Ribble Valley Borough Council
Housing & Development Control

Application no: **3/2020/0911**

Address: **Shackletons Garden Centre Ltd Clitheroe Road Chatburn BB7 4JY**

Proposal: **Proposed two-storey extension to rear and re-modelling of home and garden centre, including additional indoor and outdoor retail space and increased cafe area and play area.**

servicing/staff entrance - articulated delivery vehicle tracking

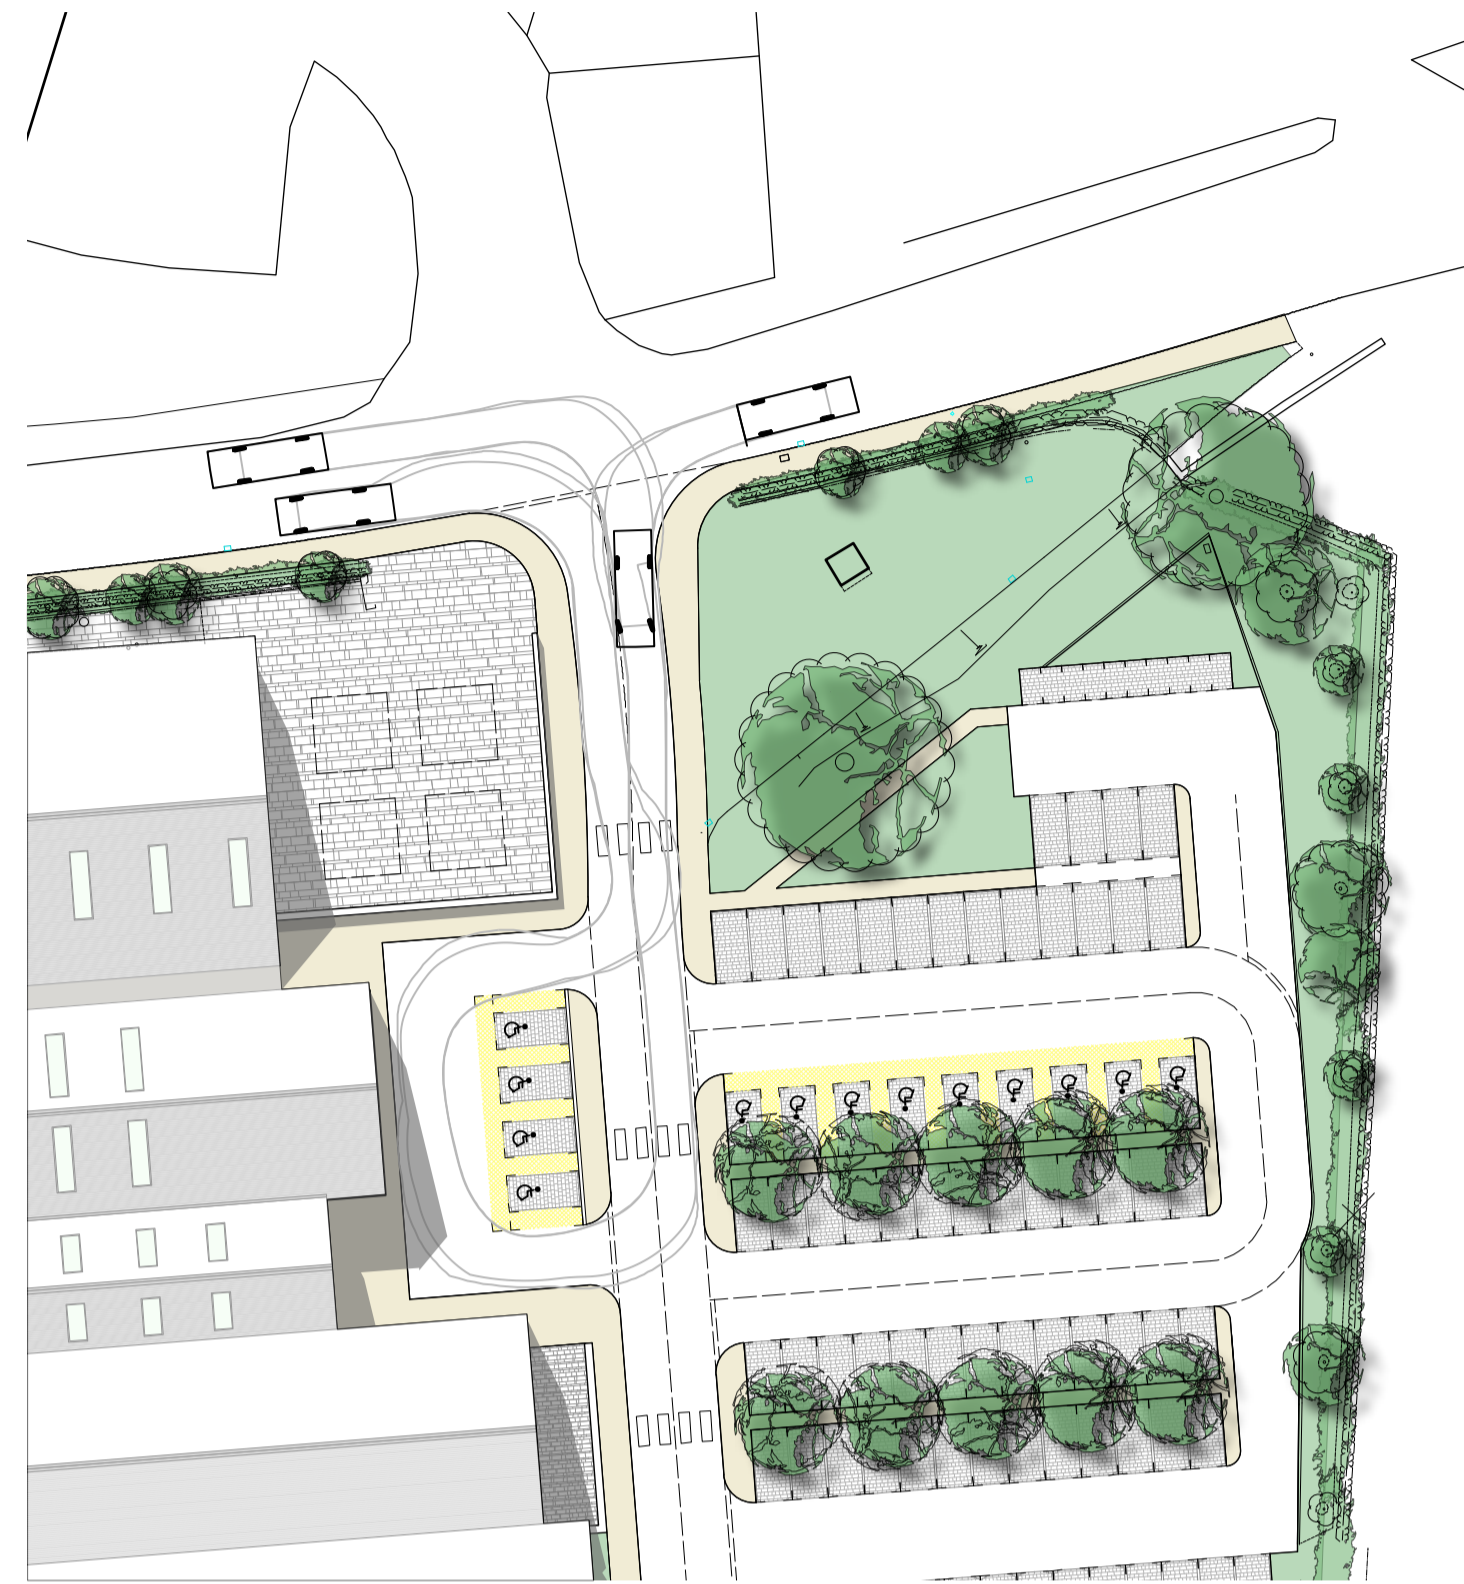
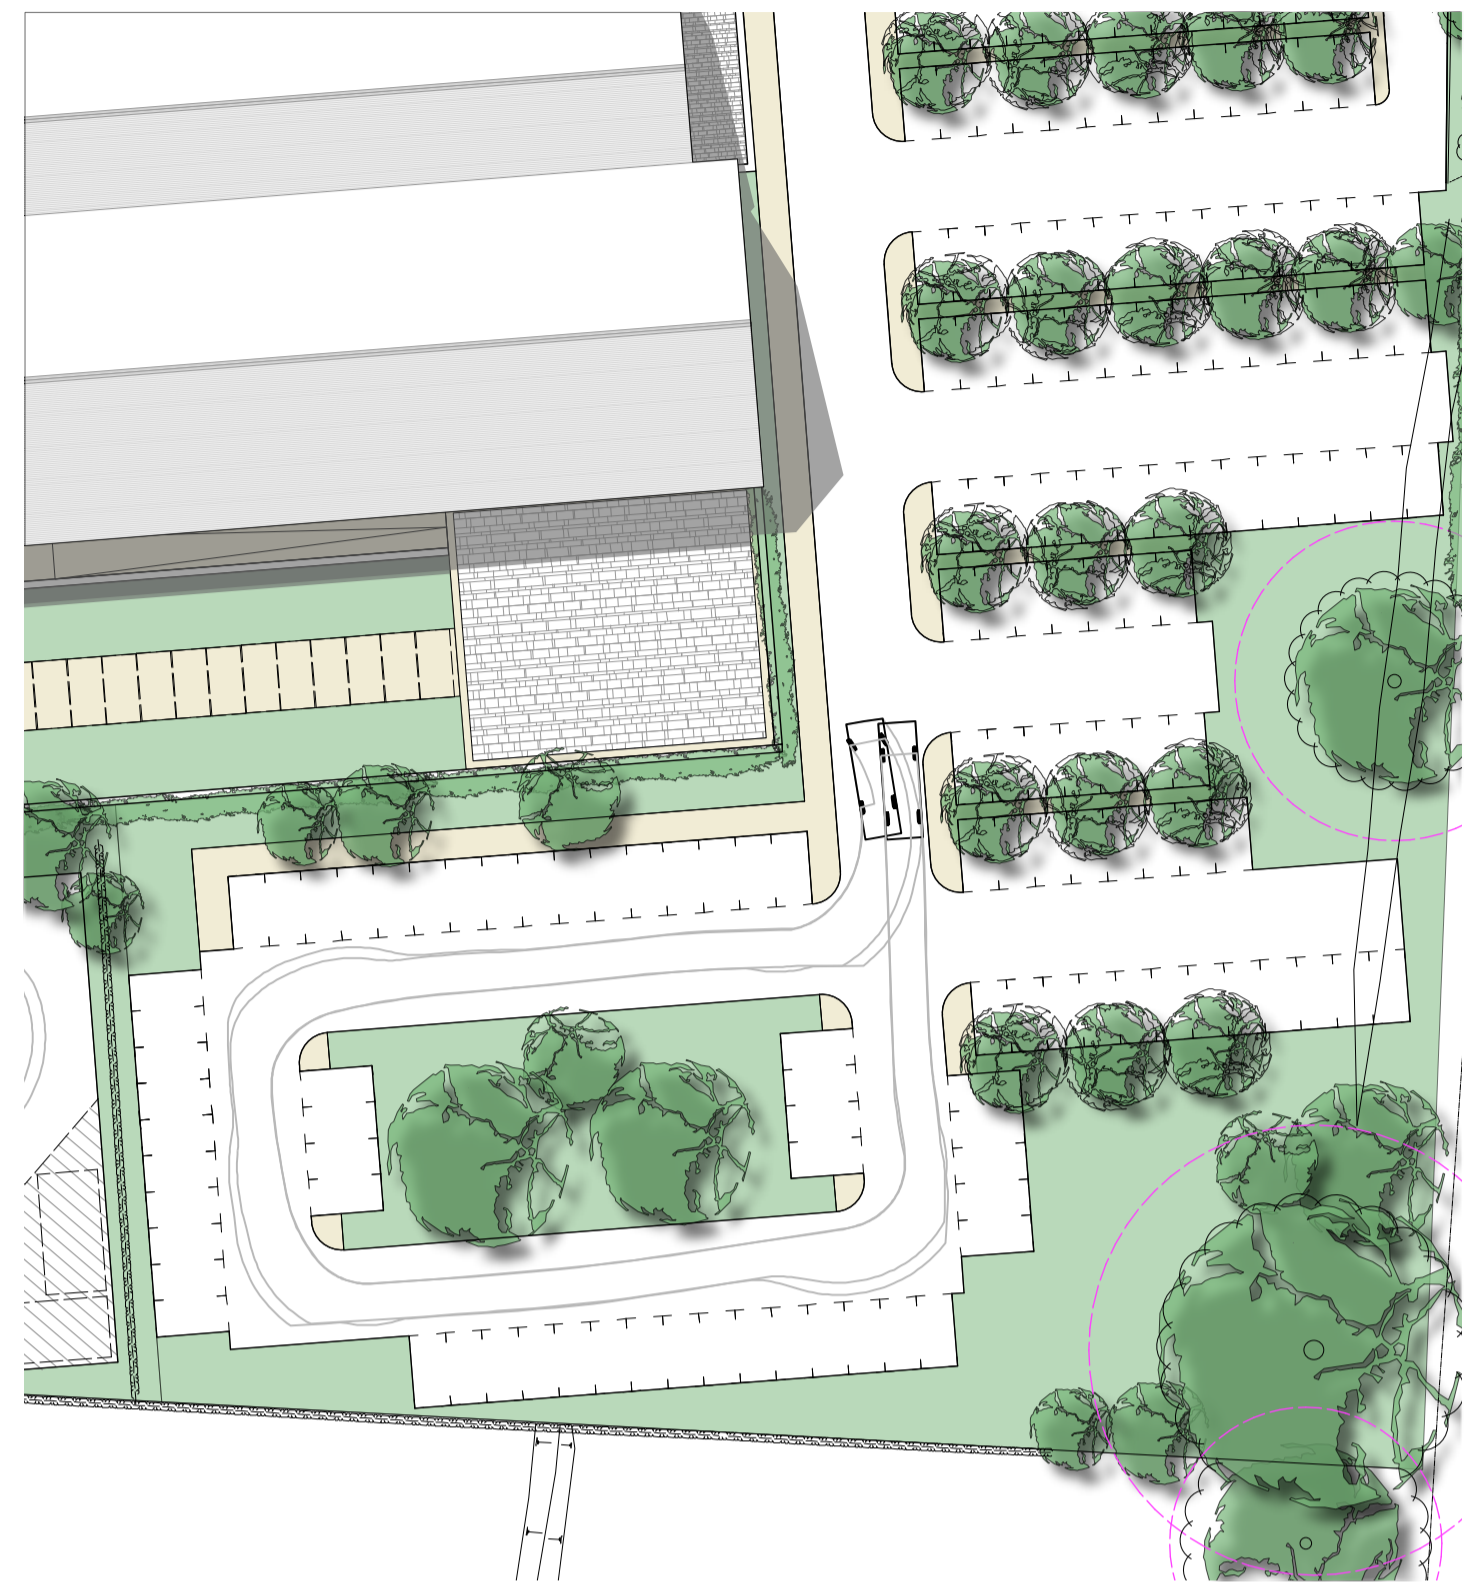
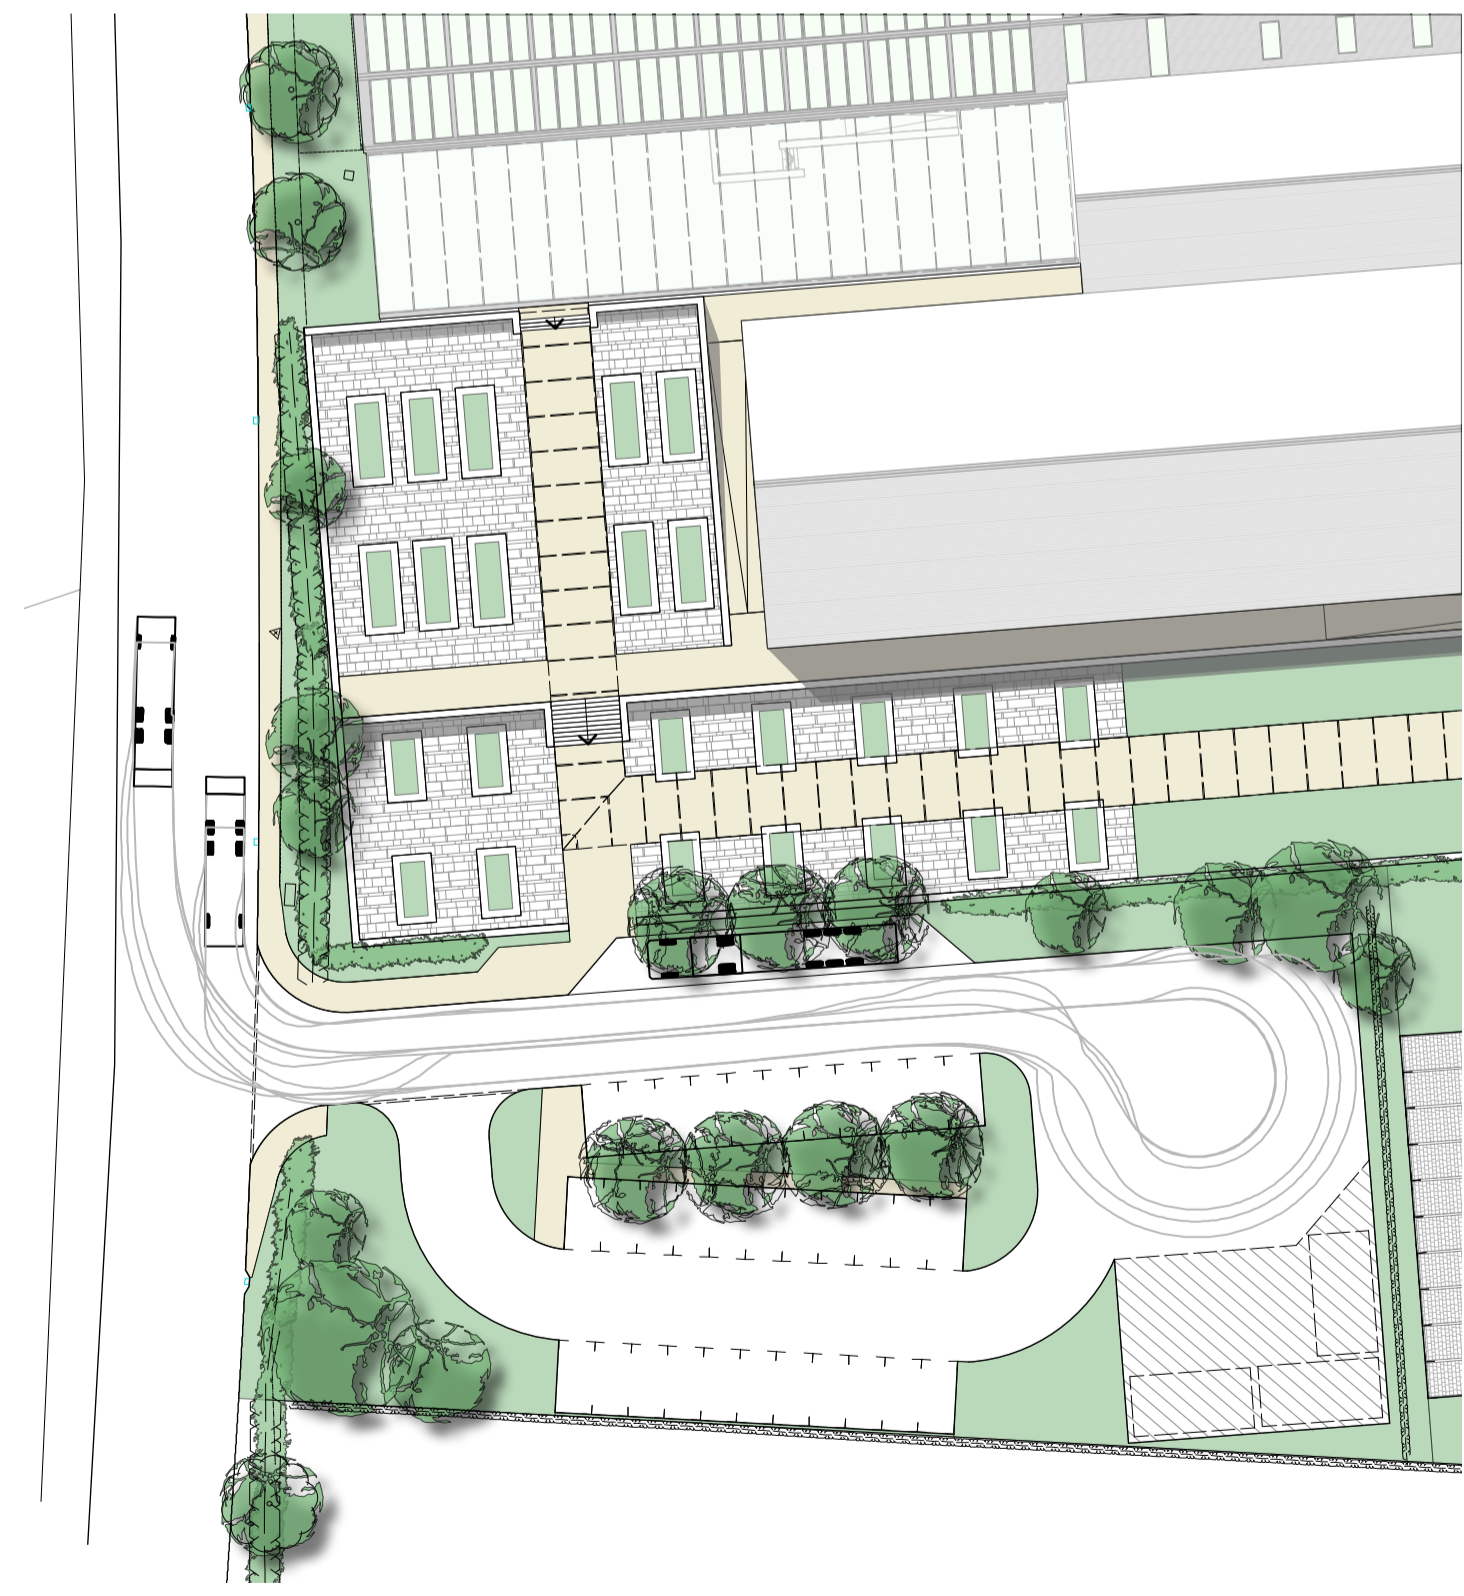
The LHA have also reviewed the amended secondary access provided on DTPC drawing titled "Updated Paths." The LHA understands that the access will be widened to approximately 19.5m wide with the north side of the access having a radius of 7.6m. The internal carriageway will also be widened to 6.75m until returning to 6m wide approximately 18m into the site.

The LHA welcome these changes and are now satisfied that the access arrangements will be safe and suitable for large, refuse vehicles to use with the swept path drawing showing that large vehicles have a clear path into and out of the site. Therefore, the LHA are satisfied that the access arrangements complies with the LHAs guidance.
